From: Sue Howell
Sent: 05 June 2018 16:25
To: Planning.Responses
Cc: Anita Gardner
Subject: FW: Planning Consultation on: A/36/18/OUT

Comments from Greenspace

Site Address: Land off Arundel Road Angmering BN16 4ET

Description of Works: Outline planning application with some matters reserved for the erection of up to 200 dwellings with access, public open space, landscaping and sustainable drainage system (SuDS) with vehicular access point from Arundel Road, one full-sized adult football pitch and the demolition of industrial units and one residential dwelling. Departure from the Development Plan.

Figure 5.2: Illustrative Masterplan.

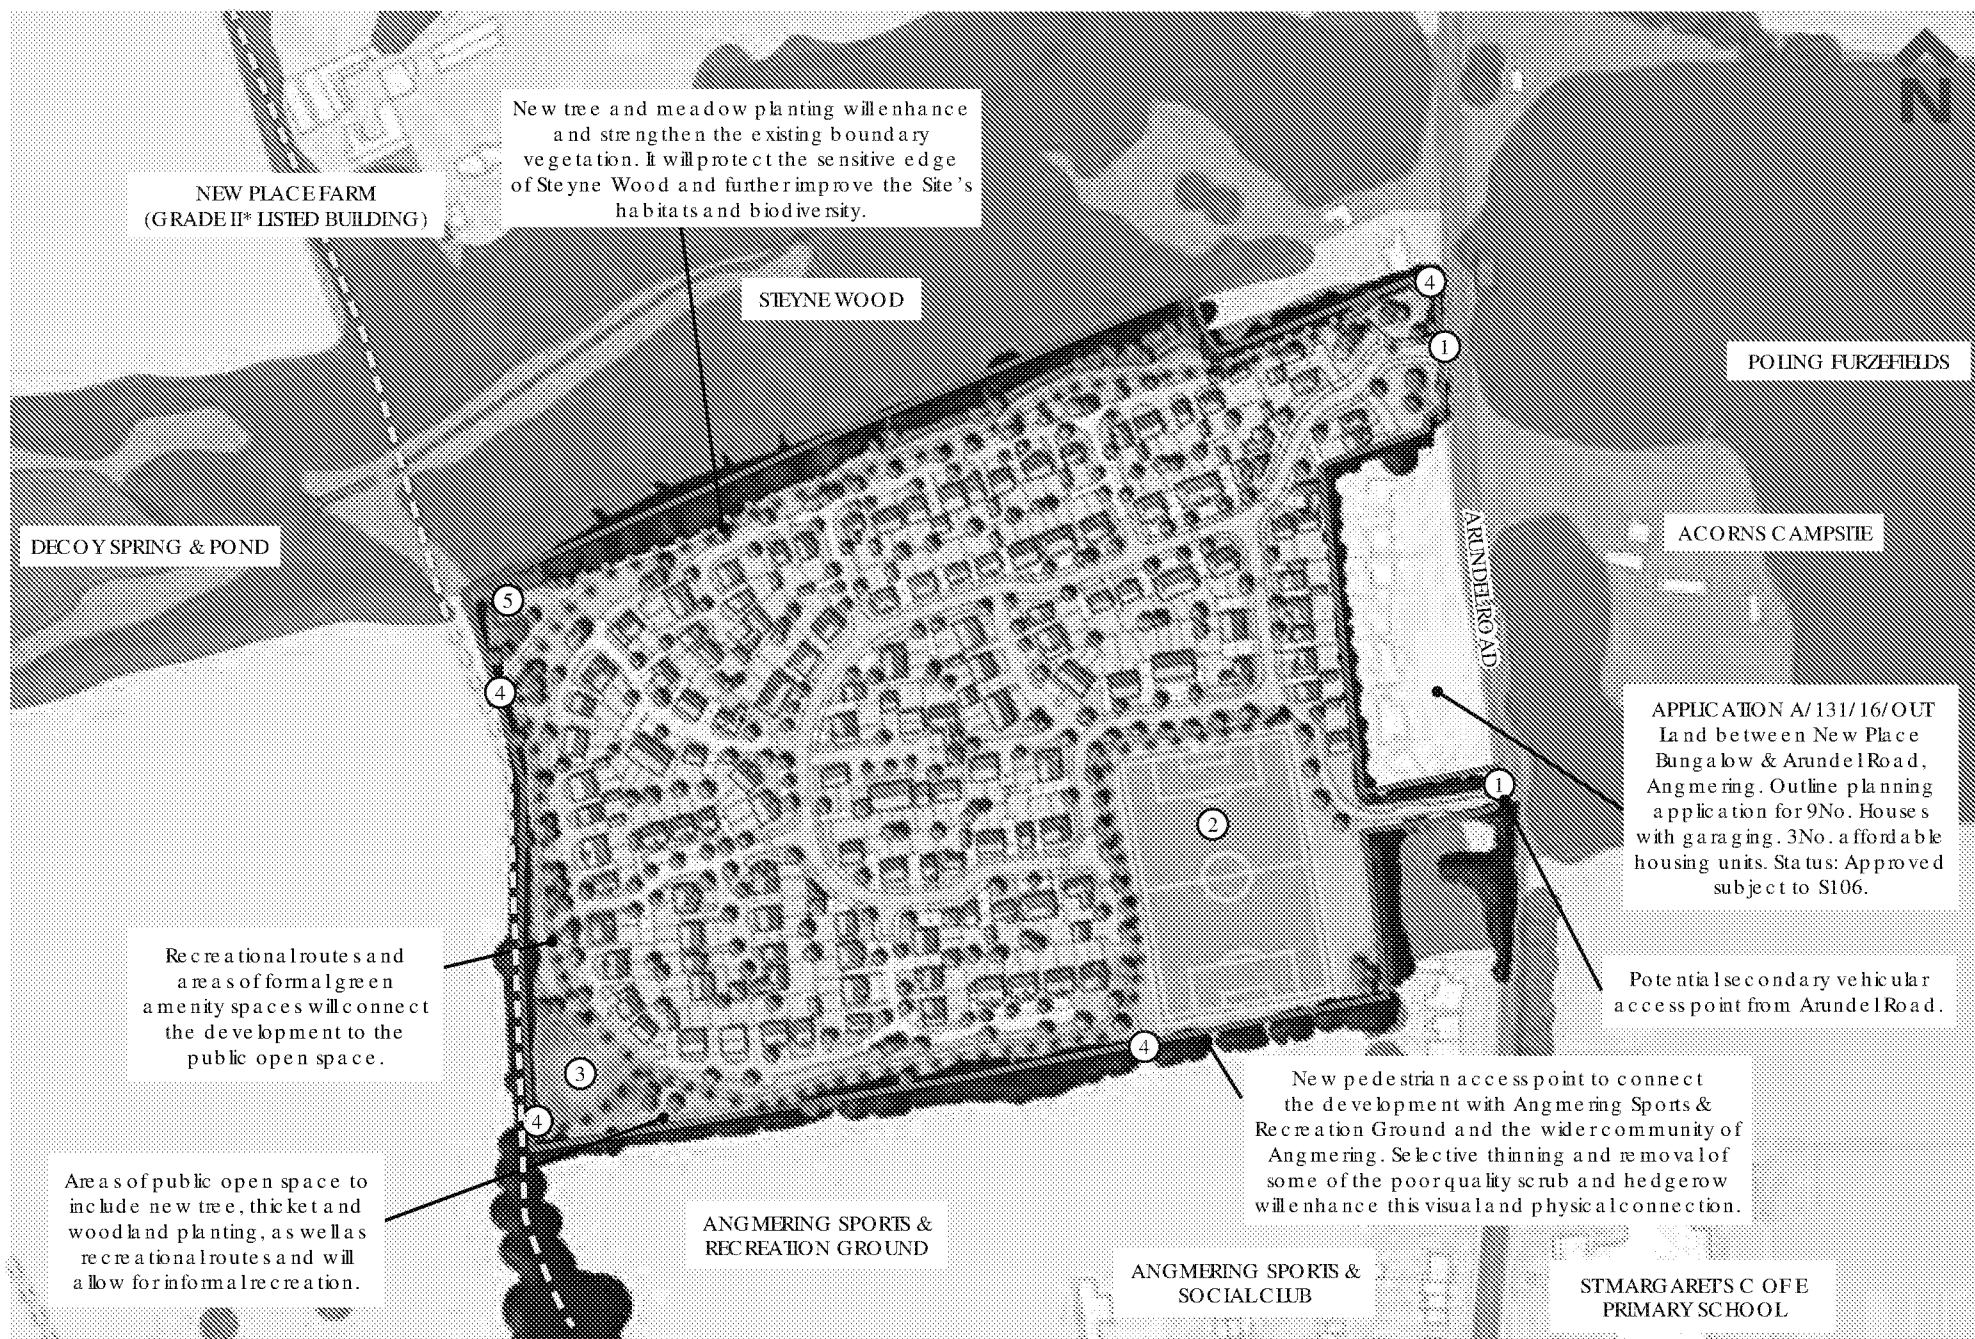
The indicative layout shows only open space to the periphery of the proposals where centrally located areas of public open space, integrated within the housing layout would be beneficial in the linking of all these areas allowing the greening of the development and for wildlife corridors to be established, increasing biodiversity across the proposed site.
